Opposition to Planning Proposal at Plane Tree Farm, Chipping Road, Chaigley, BB7

Ref: 3/2026/0587

Sections
Scale 1:250 @ A3

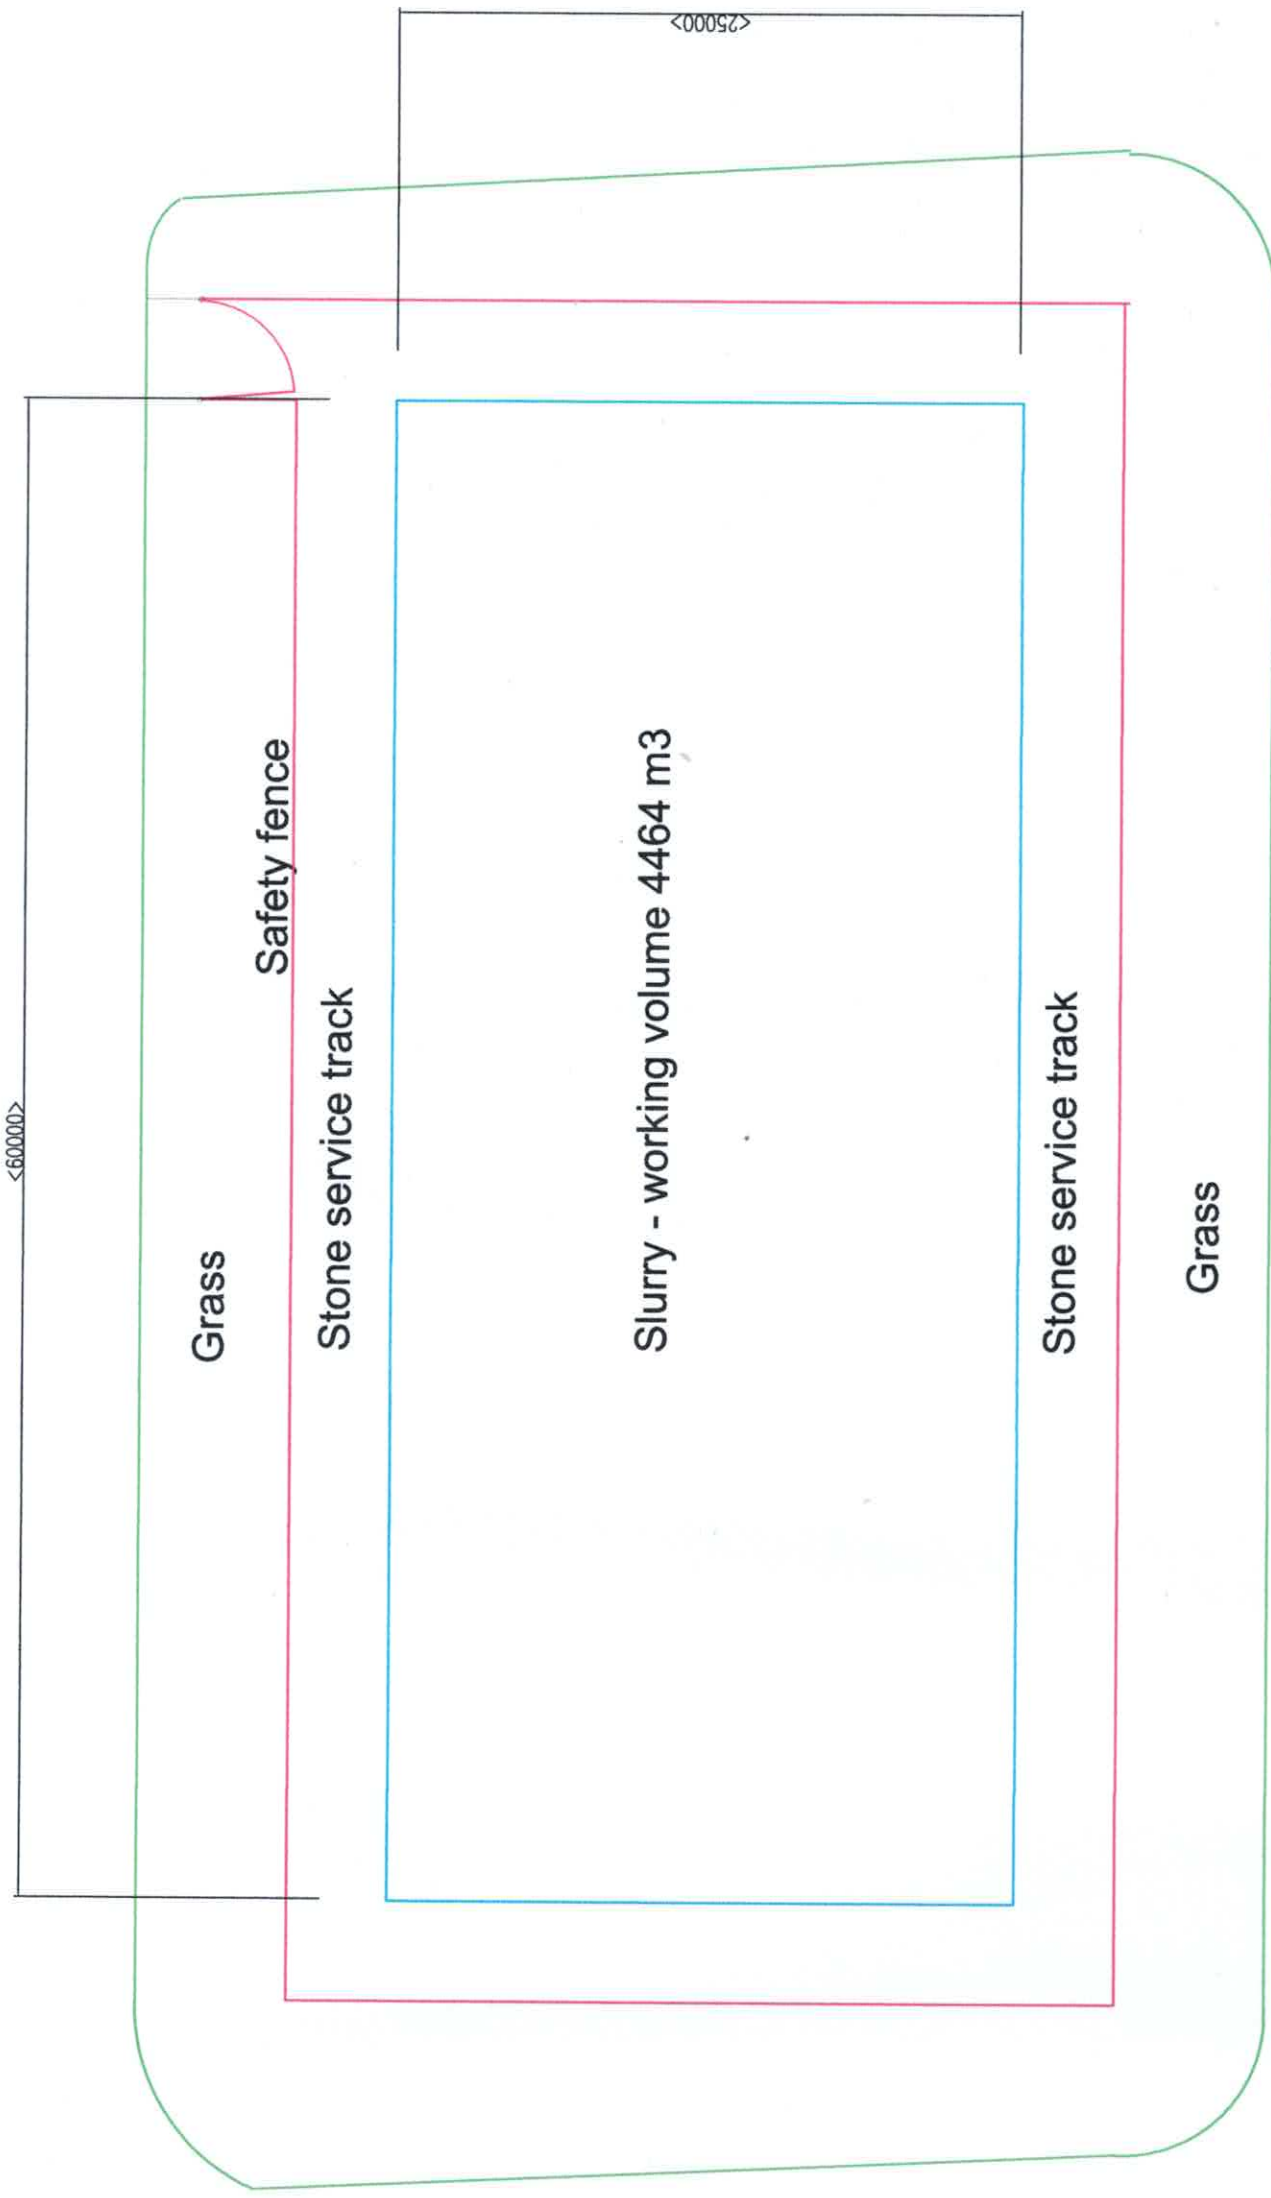
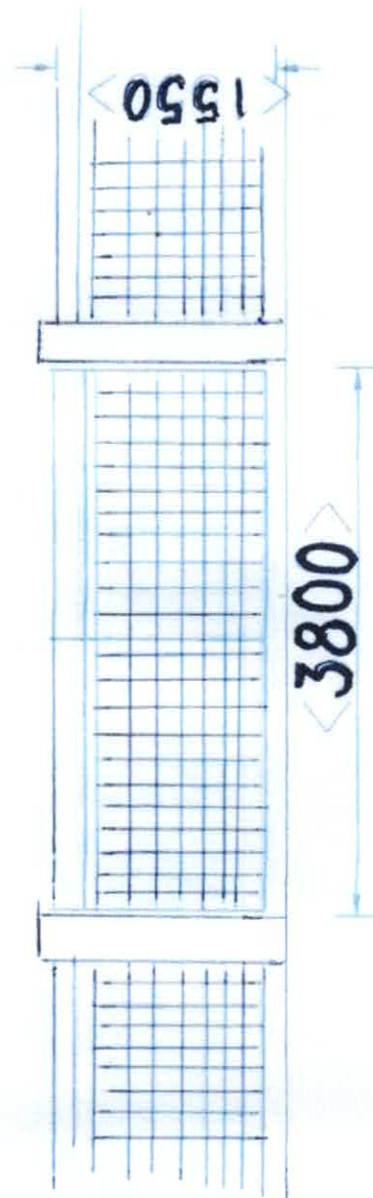
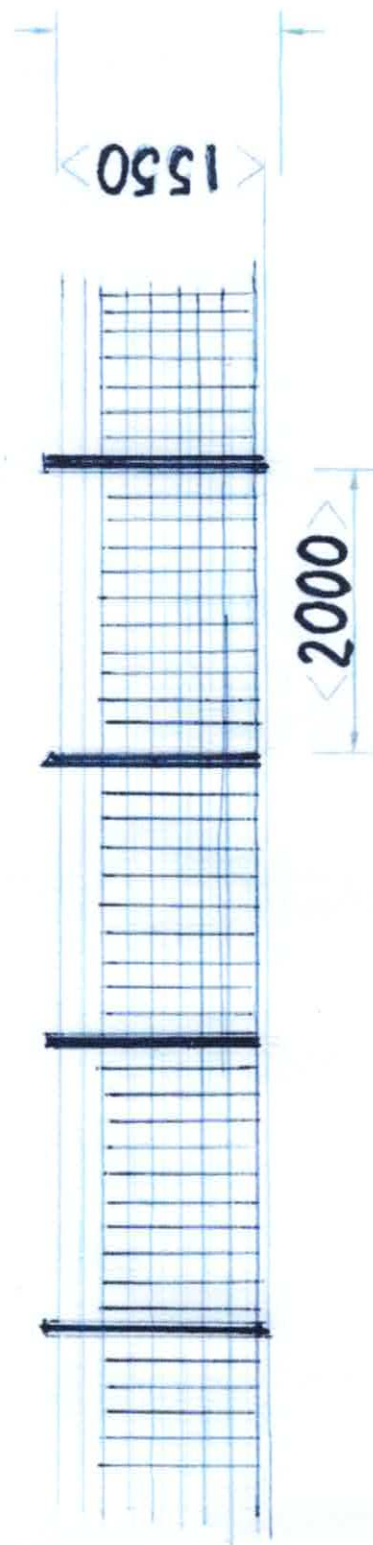
The size of the slurry lagoon has been vastly understated in the application. The application explains it will no more than 2 metres above ground level, however the design cross section shows the embankment facing the hamlet to measure a height of 3.5 metres due to the ground sloping away which would be combined with a 1.55 metre fence on top, resulting in an overall height of 5 metres, further extrapolating the impact on the landscape.

The position of the slurry lagoon is at the foot of Longridge Fell and at the top of a sloped field. I don't believe the application properly explains the topography of the landscape and I have serious concerns about how pronounced the lagoon will be in the protected landscape. The height of the side of the lagoon facing the hamlet has been vastly understated in the application. The cross section drawing explains that it will be 3.5 metres above ground level, with a 1.55 metre fence on top, however elsewhere in the application it says it will be no more than 2 metres above the ground, a clear discrepancy in the application.
